FIRE RISK MANAGEMENT, INC

Memo Report

Subject: Independent Fire Protection Review for Cumberland County Civic Center Renovations

A review has been completed of the updated sets of fire protection construction documents (CD), which have been developed to support renovation efforts at the Cumberland County Civic Center in Portland, ME. The documents reviewed included both the fire protection demolition and design drawings (updated 4/12/13), along with the design specifications (updated 4/2/13) for the various fire protection and life safety related systems and the Building Code Report (dated 4/16/13).

SHEET TITLE		A7.13	
PROJECT No.	3757.00	GRAPHIC SCALE	1" = 1'-0"
SCALE	1/4" = 1'-0"		
PROJECT MANAGER	JRB	SHEET No.	A7.13
DRAWN BY	RAJ		
CHECKED BY	MEJ

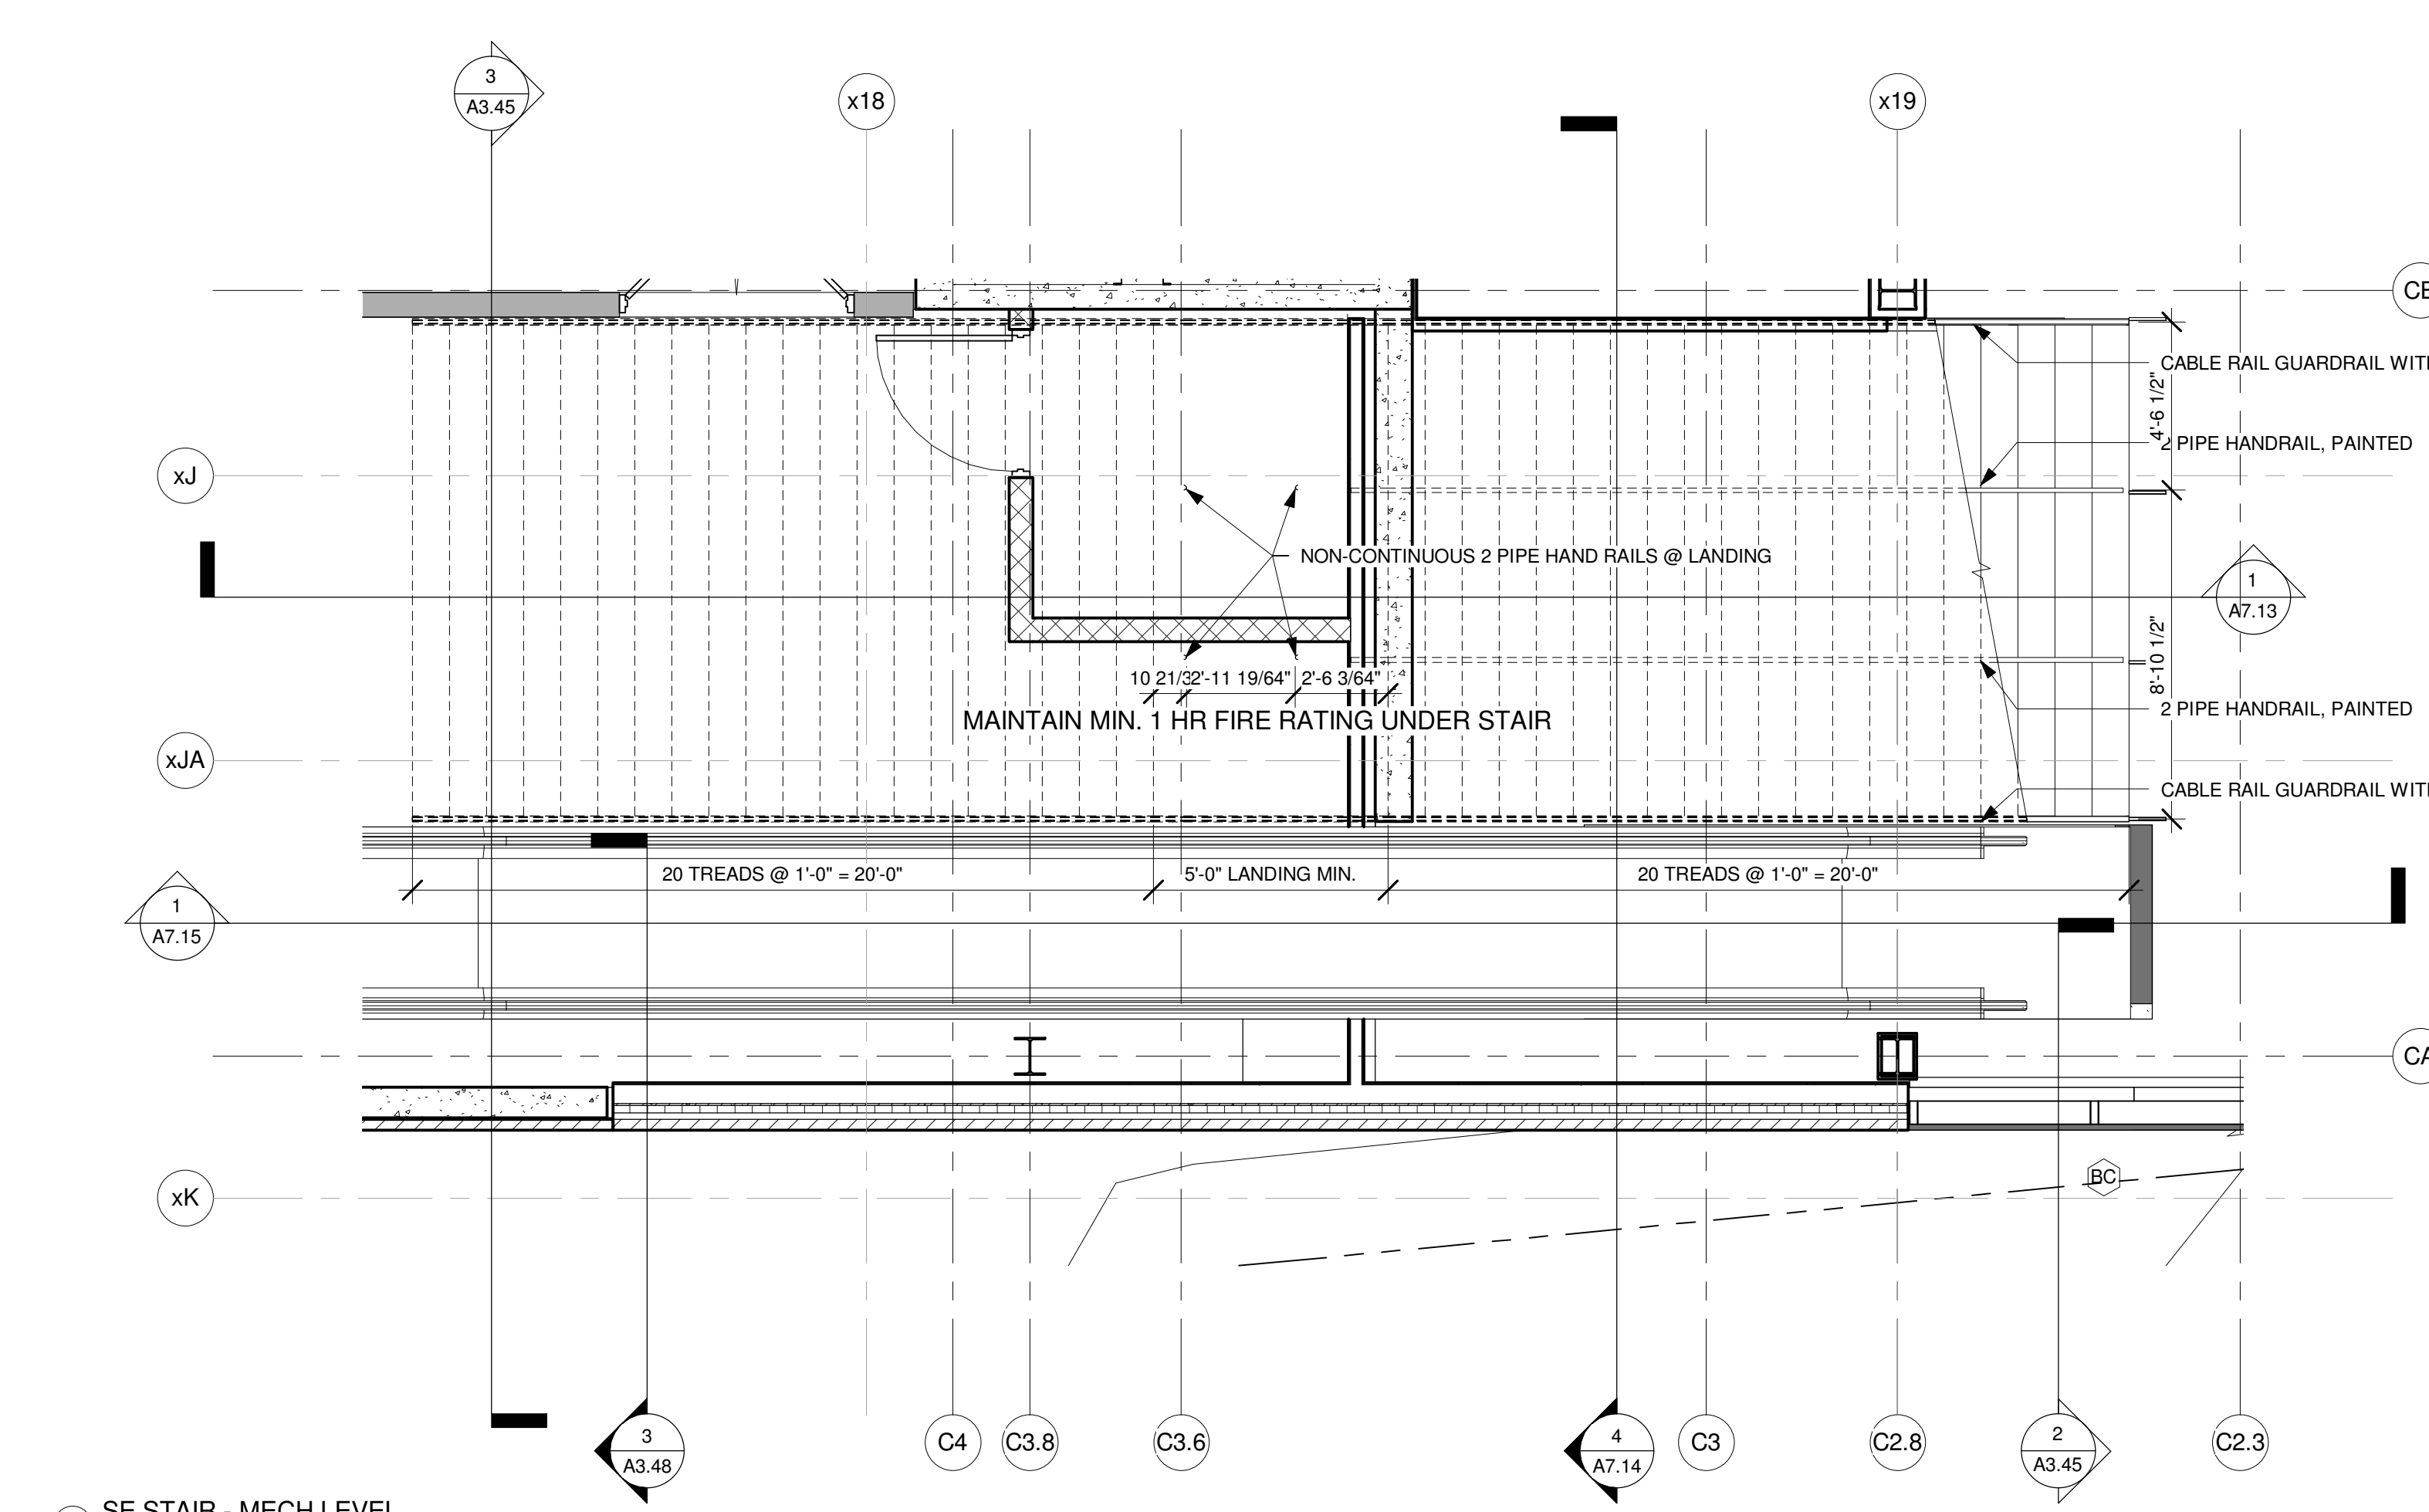
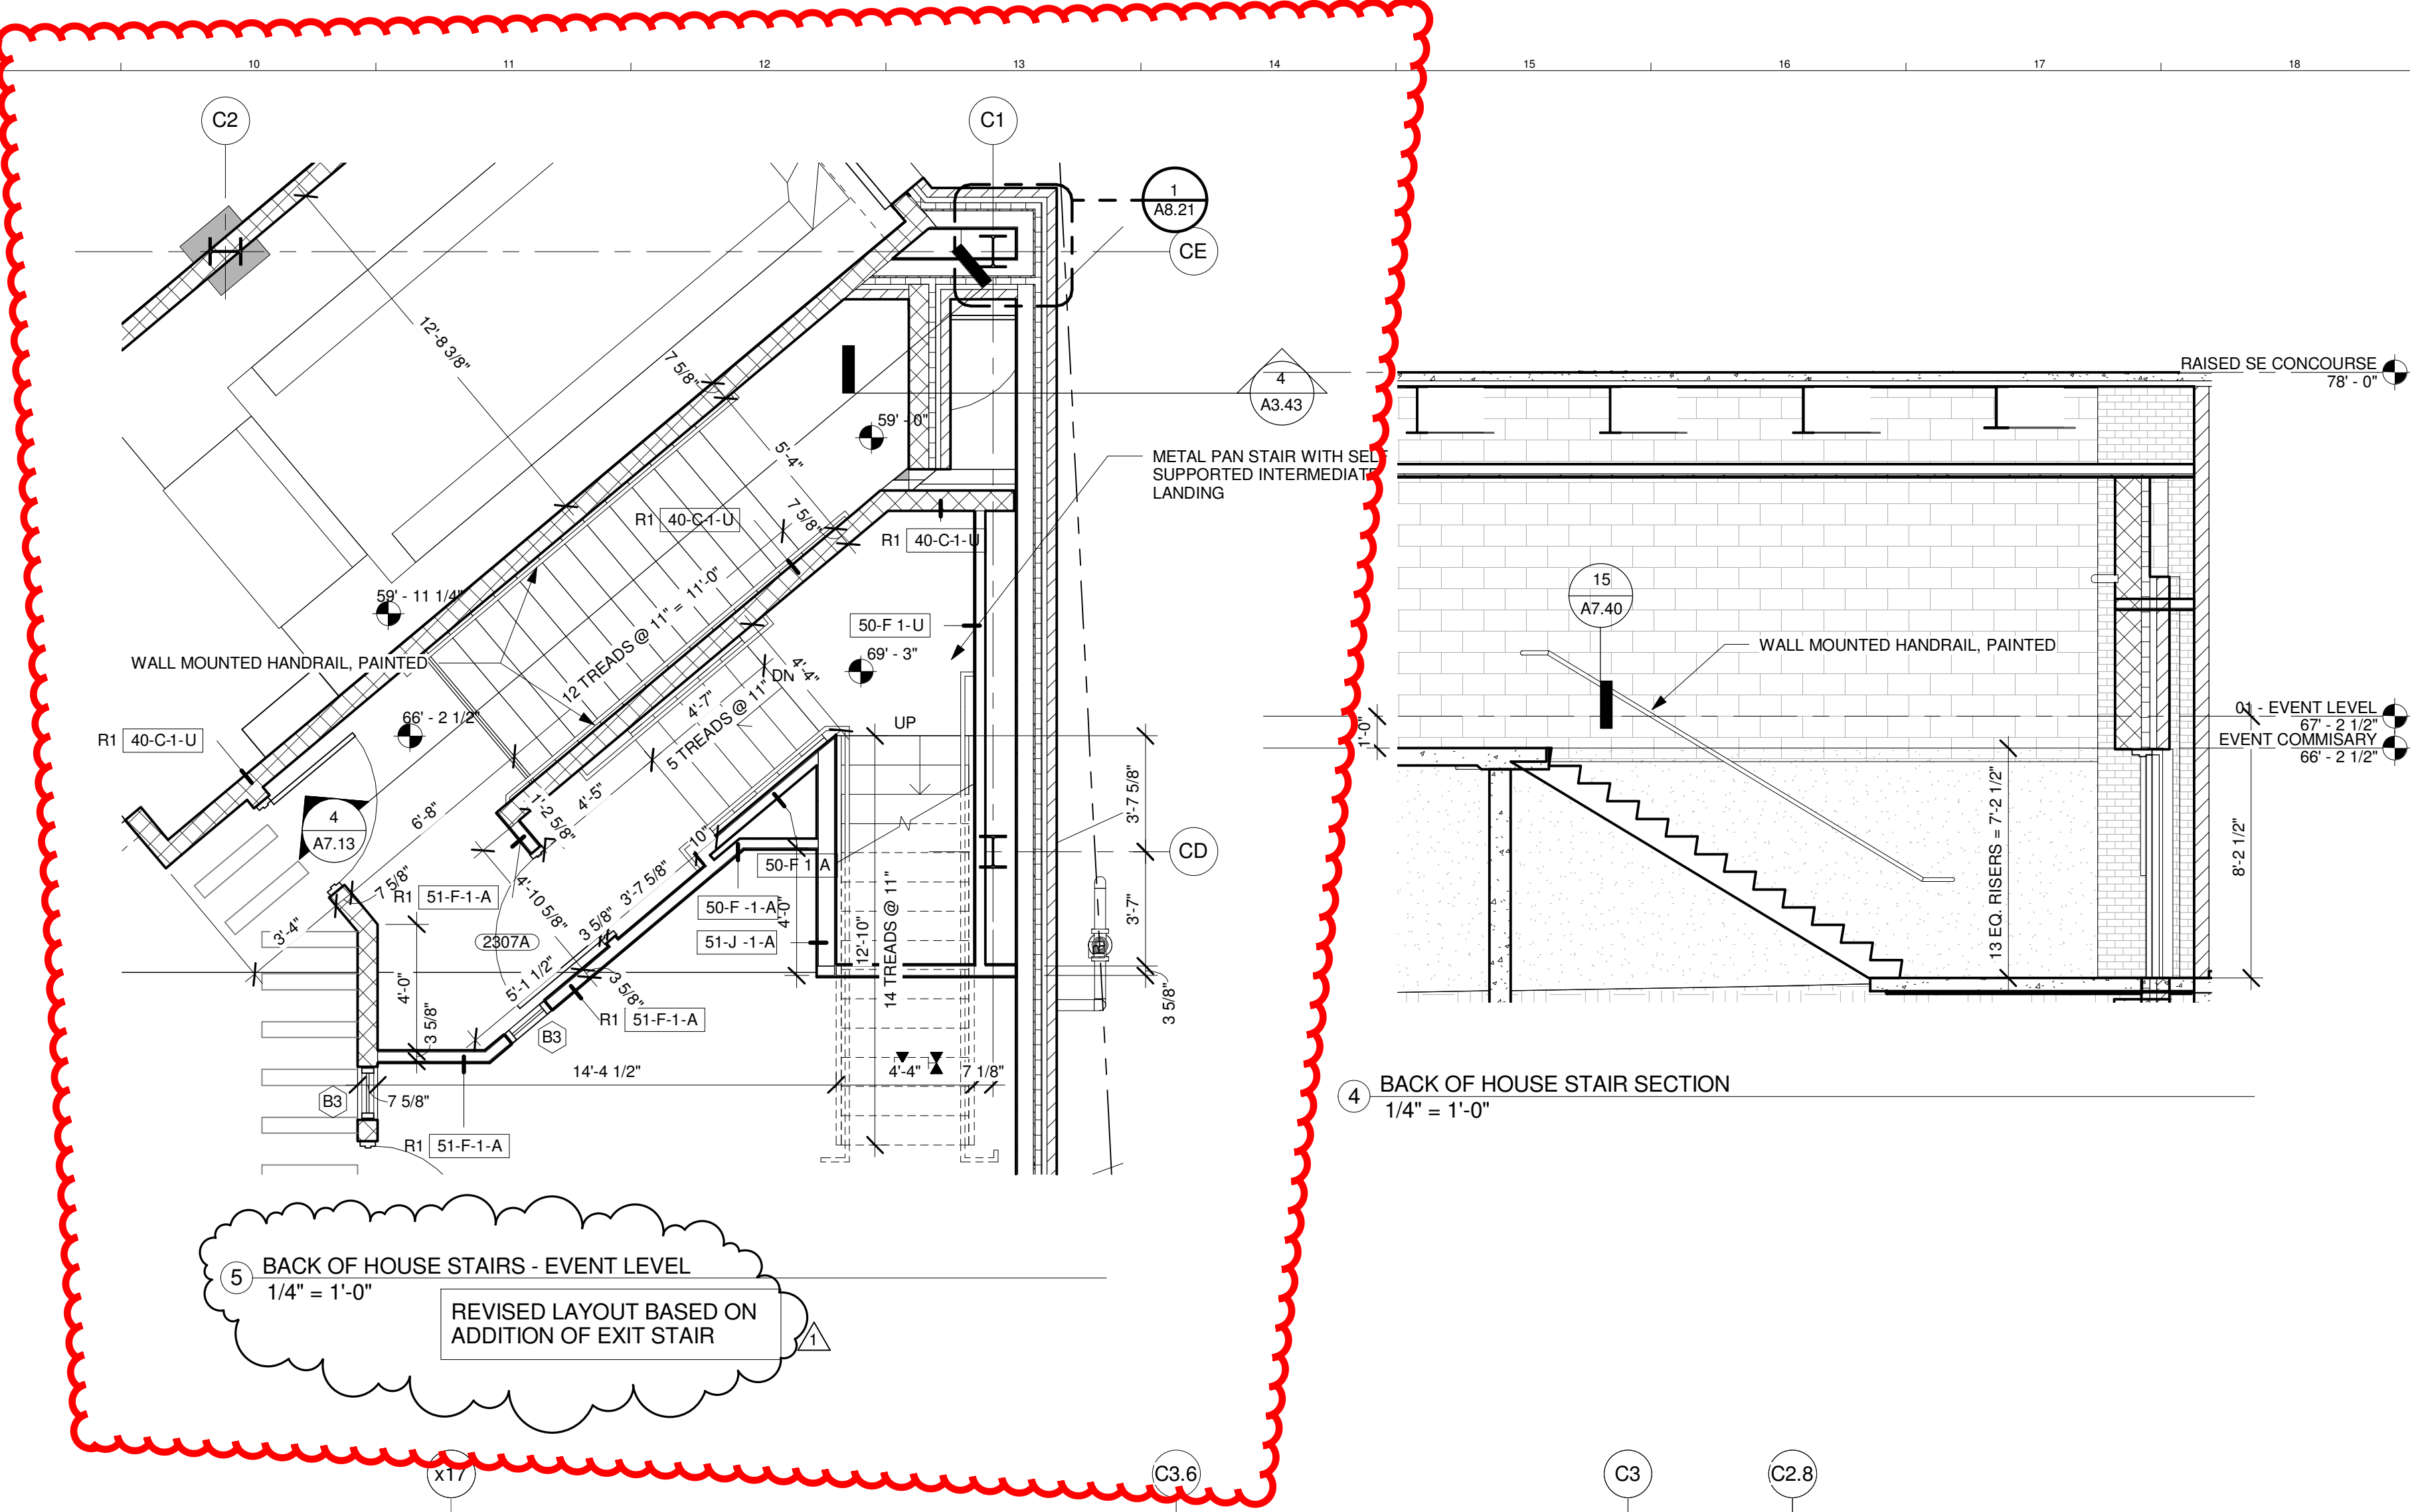
The occupant load calculations for the home team locker room and its associated spaces/areas, including office areas, do not appear to accurately reflect the load factors that should be applied within all the various spaces. Also, the stair located on the west end of the Event Level that leads up to the Concourse Level, does not appear to be provided with intermediate railings. These stairs appear to be much wider than the 5-foot (60 inch) maximum that would be allowed without the need to install additional handrails. [Note: An 88 inch maximum distance between handrails is allowed for "existing" buildings.] The current plan for the design of these stairs should be reviewed to determine if an additional handrail(s) is needed.
